**2023/1130**

Erection of single storey infill extension to south-east elevation of the building, external alterations to existing entrance, installation of cladding and render, new and replacement glazing, and roof covering. Internal refurbishment, creation of access and proposed new car park

1 Blucher Street, Barnsley, S70 1AP

Proposed Site Plan

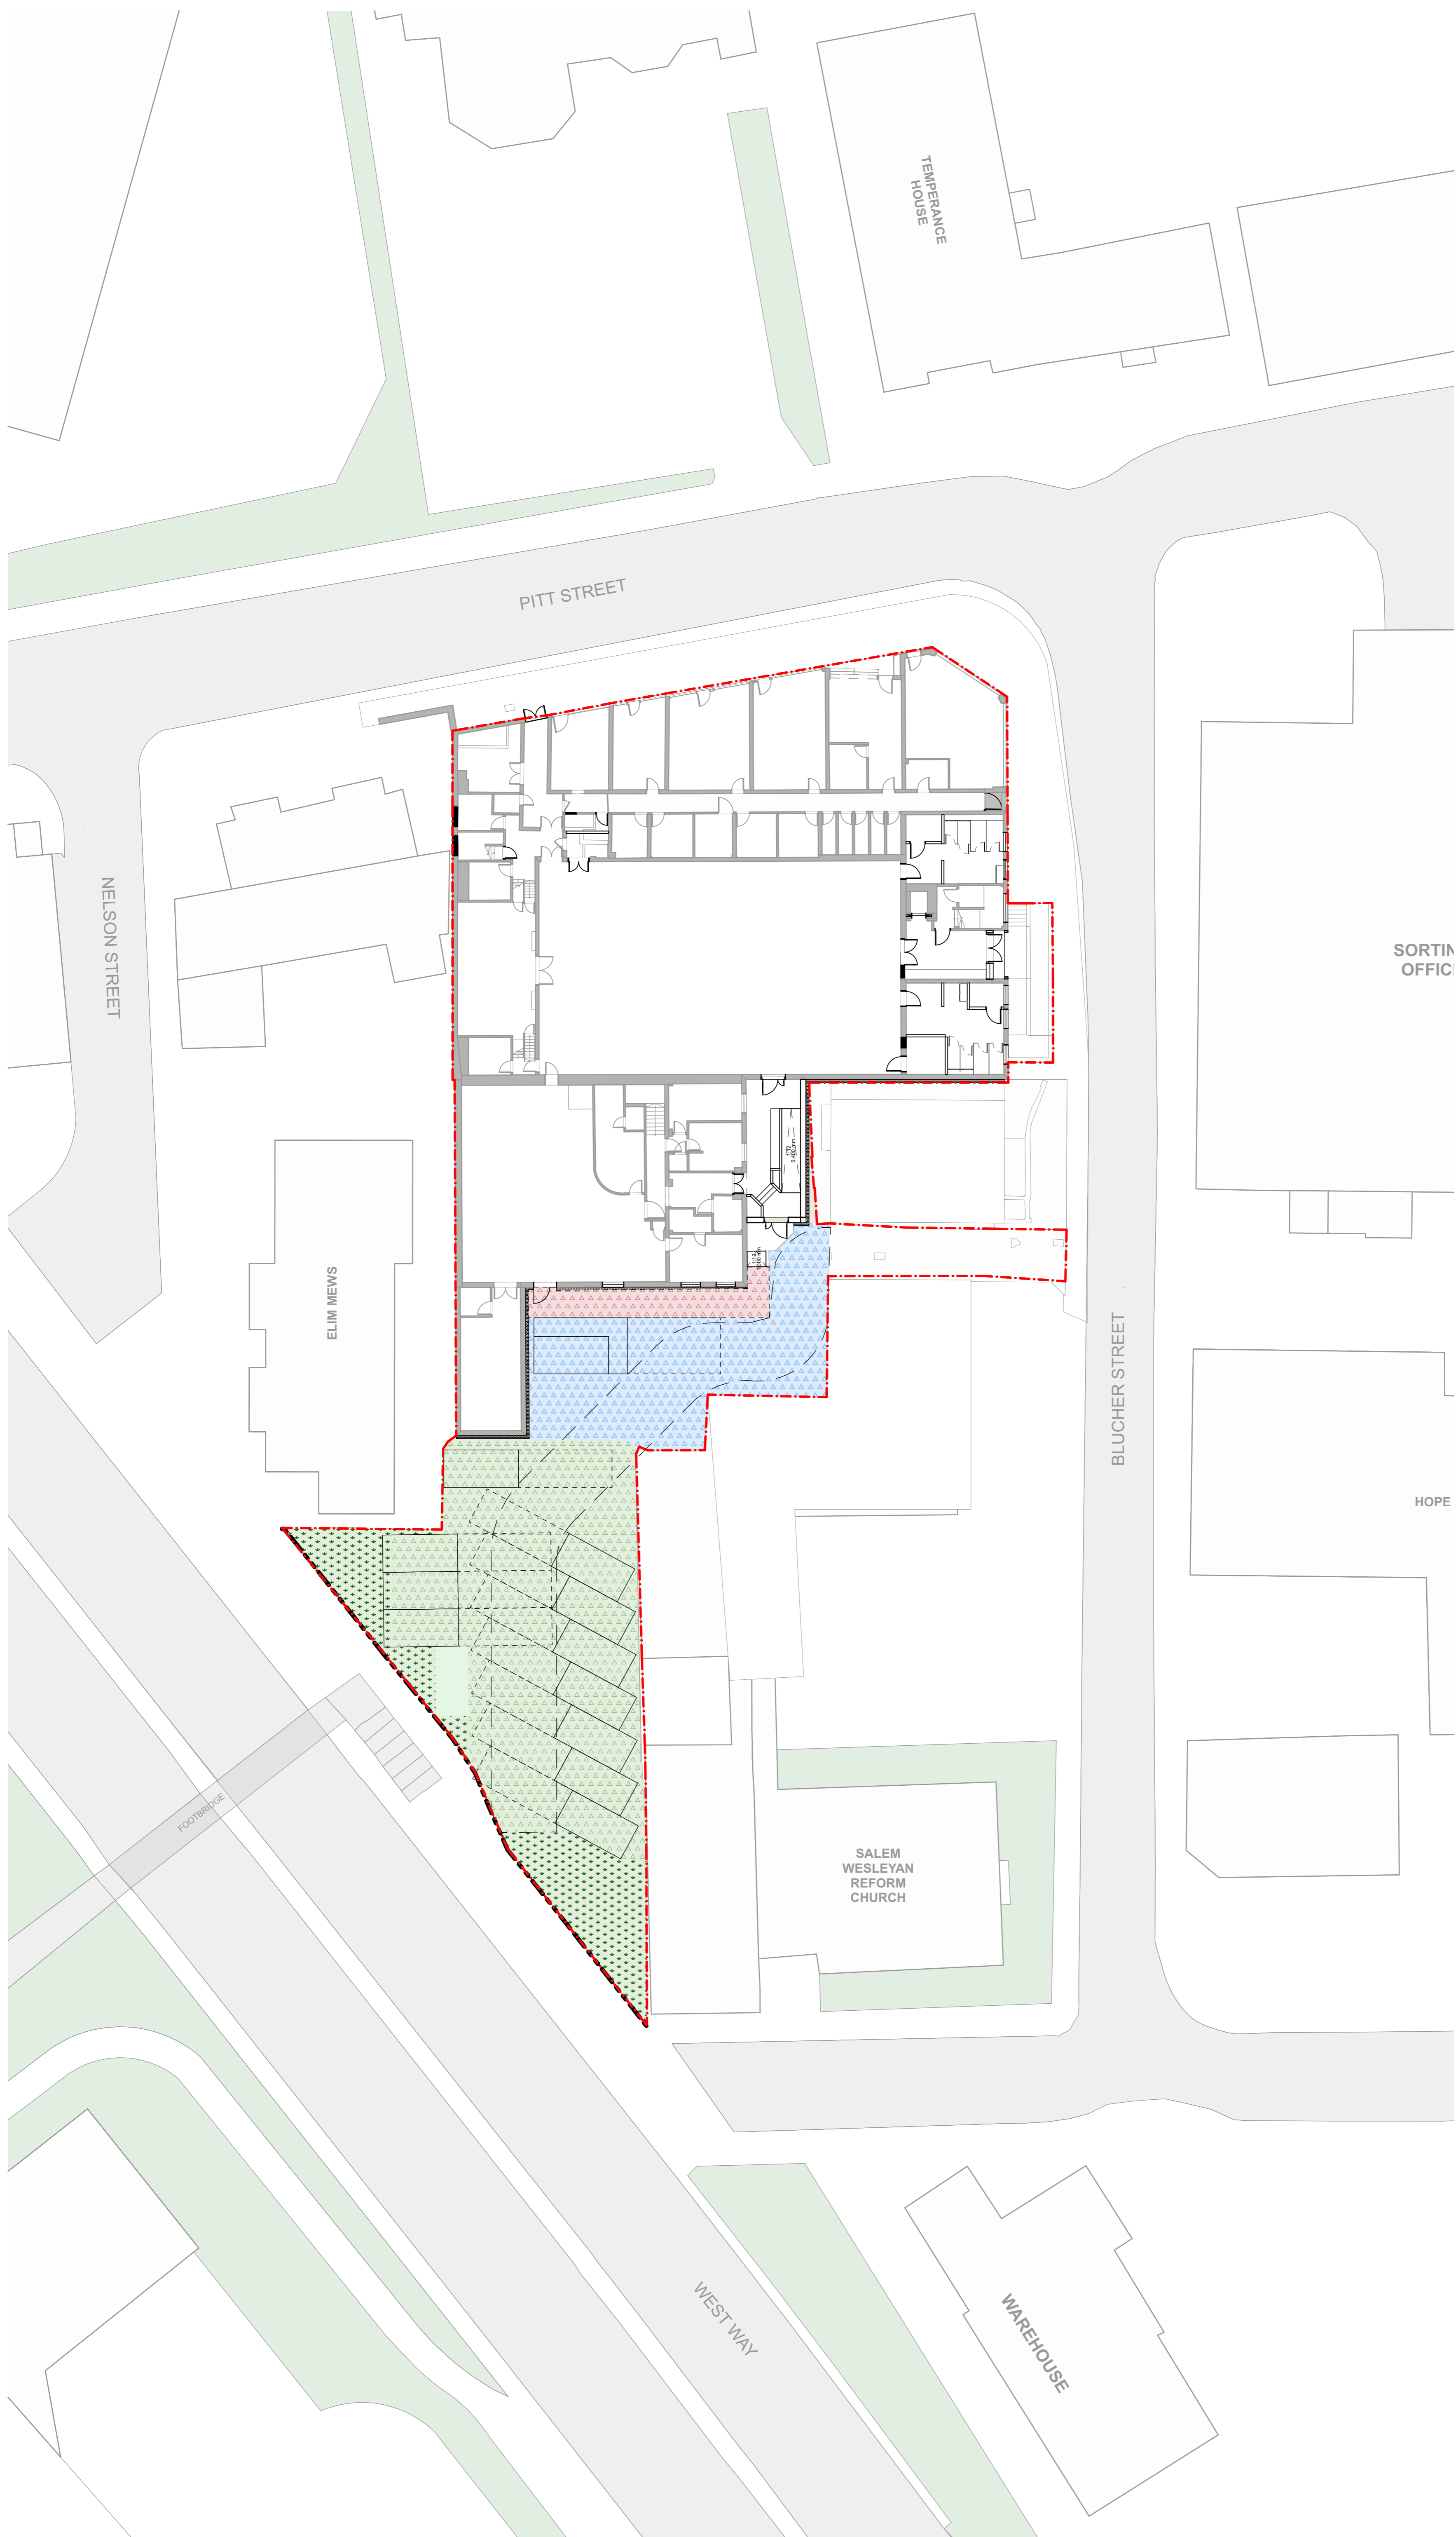
Forestry Officer – The previous attempts to retain trees have been discarded and now require all four of the category B trees to be removed, rather than the two previously agreed. No justification is provided, and the application should be amended to retain the two previously agreed trees.

In response to reconsultation on the ecology note and the agents submission: The agent is suggesting that as the trees are not ancient or veteran their removal should be considered acceptable; because it was previously agreed some trees could be removed to facilitate the scheme they should be able to remove them all; and the new car parking would adversely impact on the trees previously proposed to be retained. As previously proposed and approved, the proposed load bearing construction and permeable surface would minimise any impacts. The responses ignores our Trees and Hedgerows SPD, industry wide guidance and the NPPF which seek the retention of trees. Our previous balanced proactive approach to

allow some tree removal to facilitate the scheme cannot be used to justify the clearing of the site. The submission does not detail why retention of the two trees is no longer considered possible.

There is a listed building directly adjacent to the site. The Conservation Officer has been consulted on the proposal and has expressed concern that the retention of existing trees, additional planting and the use of appropriate materials for surfacing the car park are all important to ensure that the development preserves the setting and protects the views of the adjacent listed building.

As currently proposed, all existing trees and shrubbery on site will be lost and the arboricultural officer has expressed concern that this lacks justification and conflicts with national and local policy which seek to retain trees wherever possible.

The applicant has indicated that the previously approved car parking layout is not capable of being used in full and that there are some structural/fabric issues being experienced by the listed church which may be exacerbated by retaining existing or planting new trees in the vicinity. However, no detailed evidence has been supplied to justify these positions.

Since the principle of development is considered to remain acceptable in principle but the details are not considered acceptable, it is recommended that planning permission is granted subject to a condition requiring that a revised parking scheme is submitted, securing retention of the two previously retained trees on site, with a revised parking layout.

The submission also indicates that the applicants have agreed in principle to replacement planting on a 2:1 basis either on or off site. Informal advice from the Parks Officer has advised that replacement planting should be secured on a 3:1 basis. Conditions are recommended to secure on and off site planting, and tree protection measures for the trees to be retained on site.

**PROPOSED SITE LOGISTICS KEY**

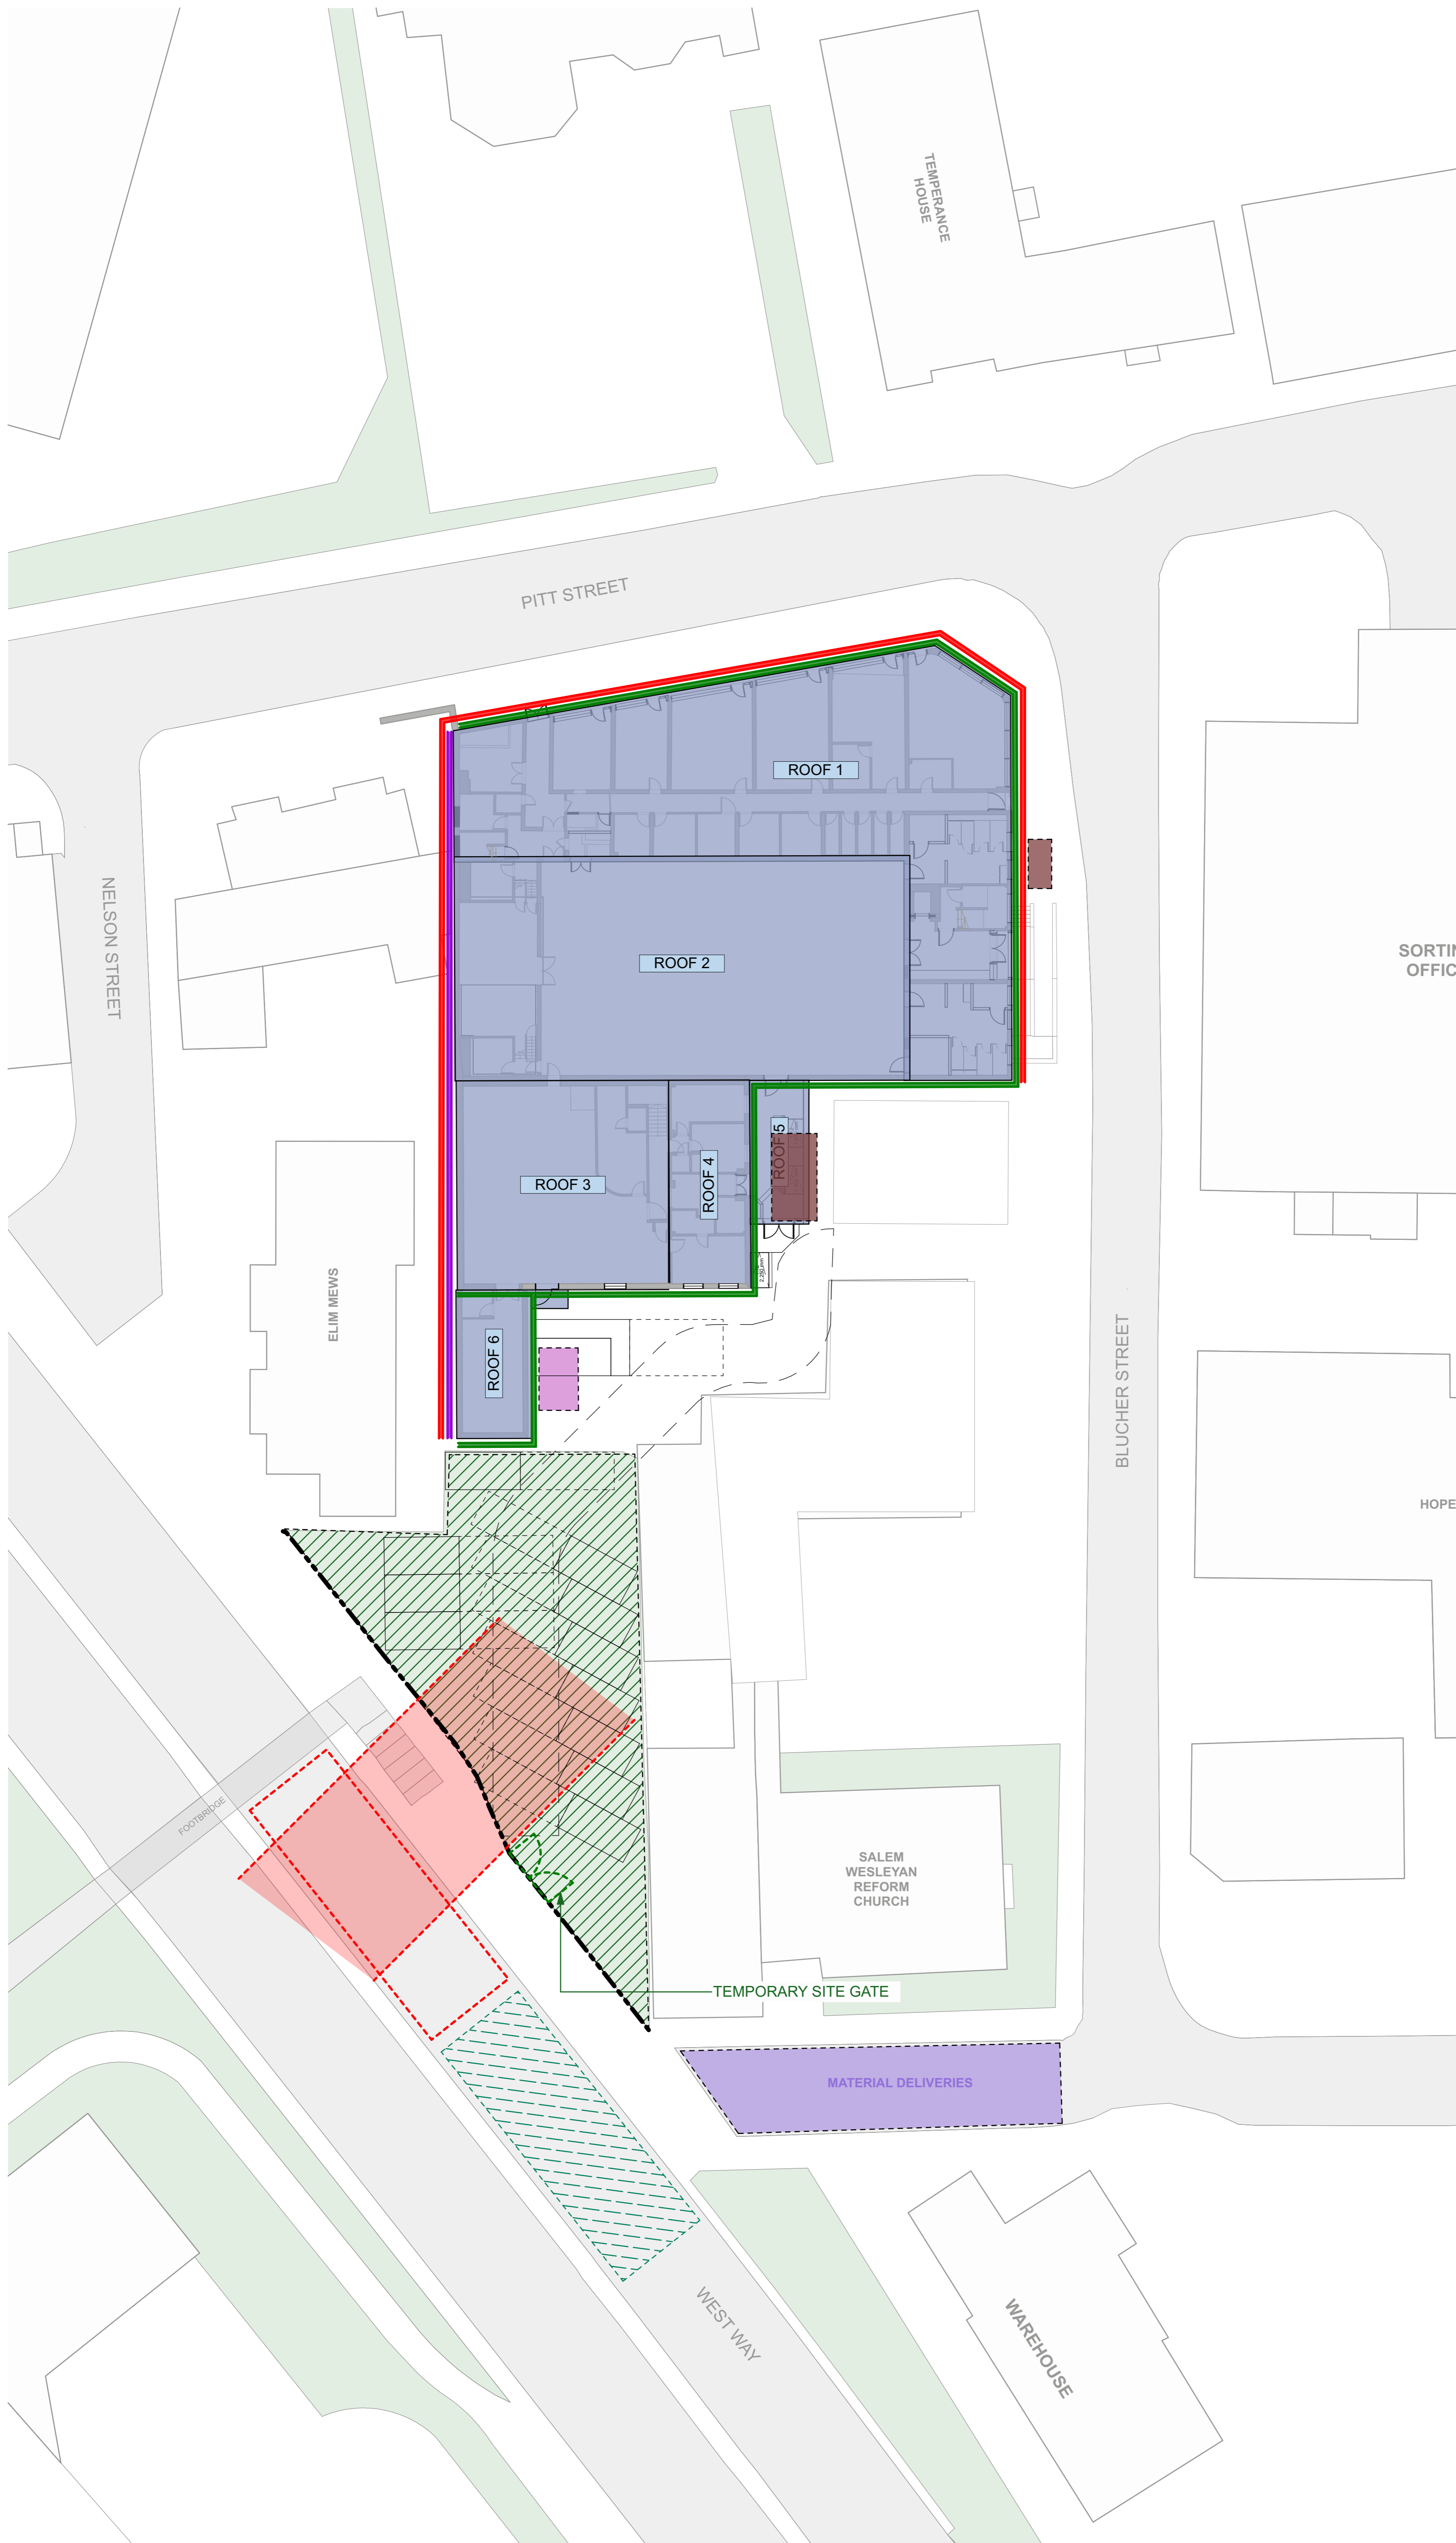
In response to reconsultation on a construction method statement, it has been confirmed that this does not include much at all in the way of dust or noise management and is not acceptable.

Pollution Control – no objections subject to conditions requiring a Construction Environmental Management Plan to be agreed and implemented; and to restrict hours of construction
